**Planning Act 2008 - Application for a Development Consent Order for Fosse Green Energy**

**Planning Inspectorate Case Reference: EN010154**

**Change Notification**

Fosse Green Energy - Solar Farm
Viewpoint 35: View south-east from Grange Cottage

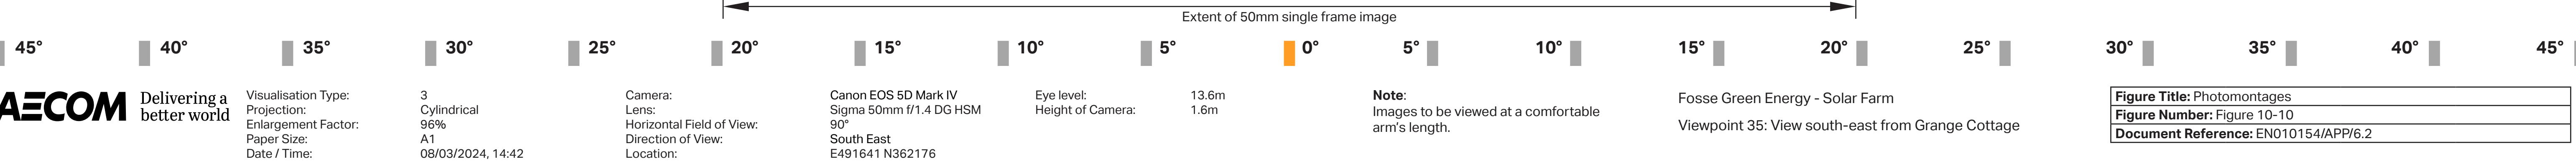
### Removal of Solar Infrastructure from Field 46

The landowner at Grange Cottage, Bassingham Road raised concerns regarding the Solar PV Array proposed in Field 46, located immediately south east of Grange Cottage. Similar concerns were raised by Historic England in relation to Field 46, due to the impact of the Solar PV Array on views towards heritage assets (both designated and non-designated).

In response to these concerns, the Applicant has engaged with the relevant interested parties and subsequently amended the design of the Proposed Development to remove the previously proposed Solar PV Array from Field 46.

The removal of the Solar PV Array from Field 46 reduces the visual impact at Grange Cottage to not significant in year 1 and year 15 (Winter) of the Proposed Development's operational lifespan.

There are no additional works proposed in place of this, meaning that the only amendment to the Proposed Development is the removal of the Solar PV Array from Field 46.

This amendment is reflected in the updated plans and the updated photomontages that have been prepared, both of which are attached to this letter for the Examining Authority's information. Additionally, an updated version of Chapter 10: Landscape and Visual Impact of the Environmental Statement has been prepared and is all attached to this letter for the Examining Authority's information.
